Phone: 0300 123 6780  
Email: [developeras@lancashire.gov.uk](mailto:developeras@lancashire.gov.uk)  
Your ref: 3/2025/0931  
Our ref: 3/2025/0931/HDC/KW  
Date: 13 January 2026

**Location:** 10 Peel Park Close Clitheroe BB7 1EX  
**Proposal:** Proposed demolition of garage and conservatory to create the space for a single-storey wrap-around extension and front porch.  
**Grid Ref:** 374607 441173

A1.4 A

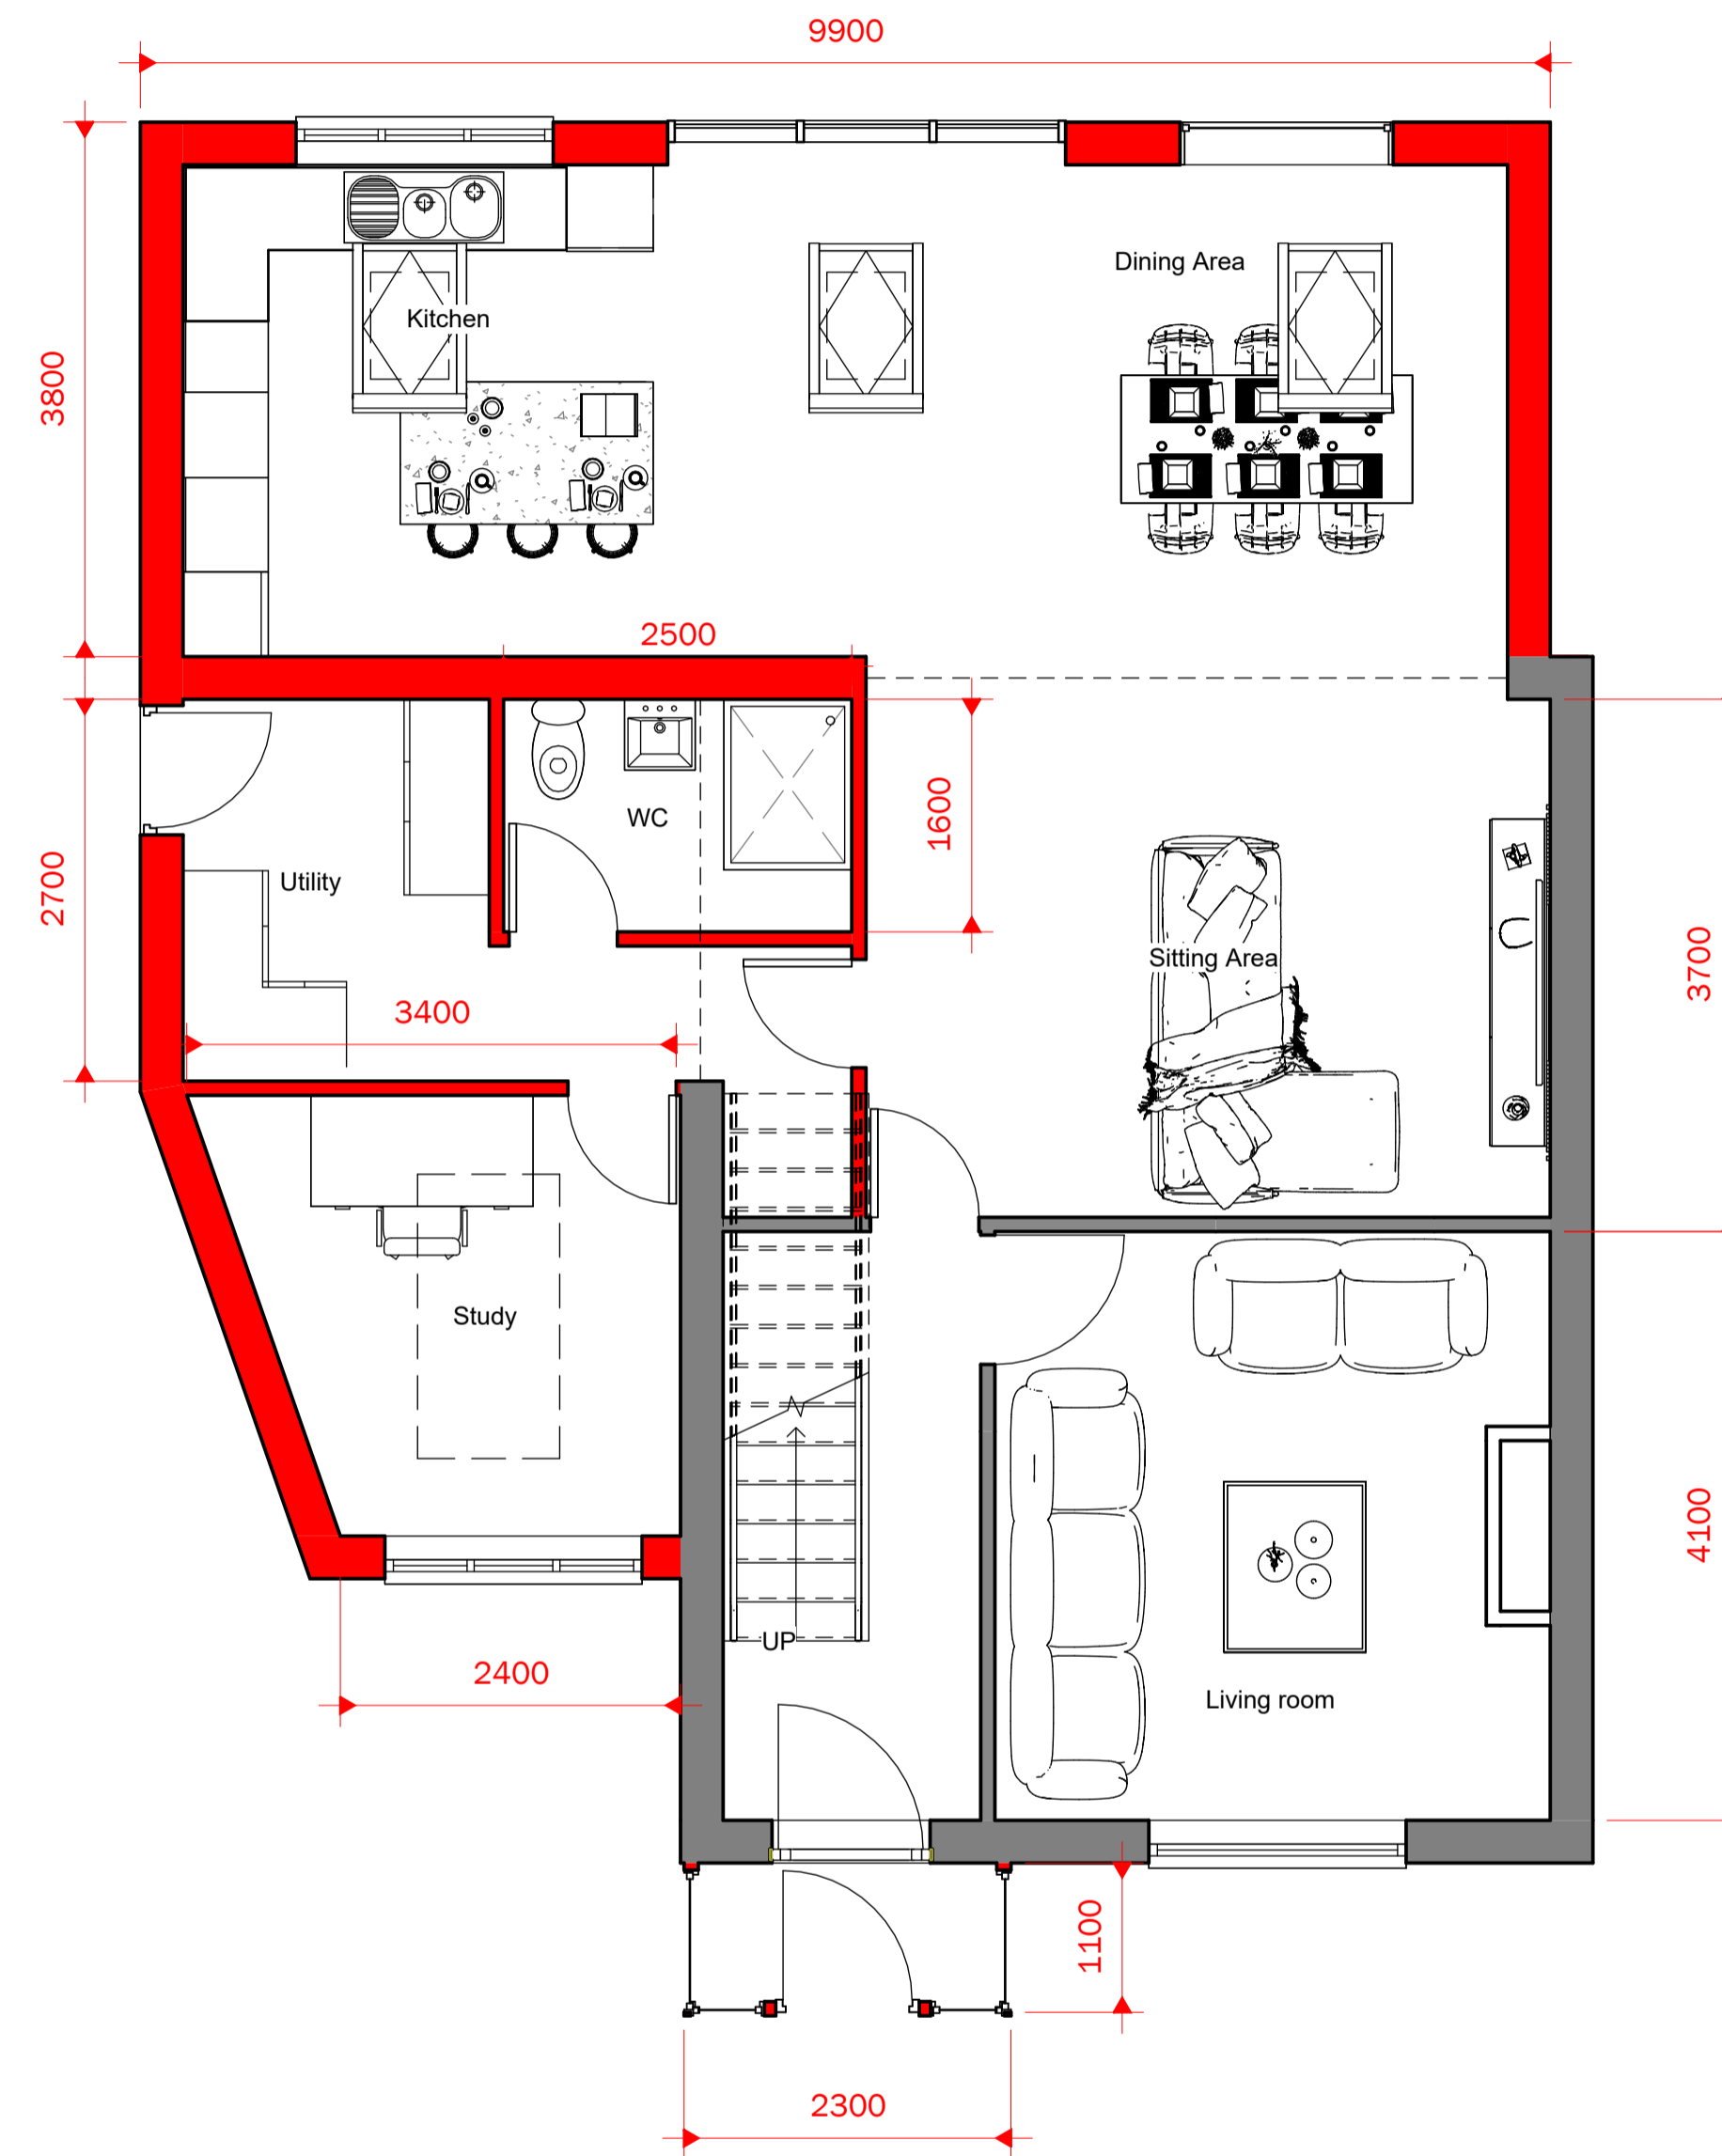
The LHA have reviewed the amended floor plans, drawing A1.4 A, and the proposed site plan, drawing A1.2 A. The proposal will not increase the number of bedrooms within the dwelling and off-street parking provisions will be retained, providing 2 off-street parking spaces, which is appropriate for the size and nature of the dwelling. As such, the LHA is of the opinion that the proposal will have a negligible impact on the surrounding highway network.
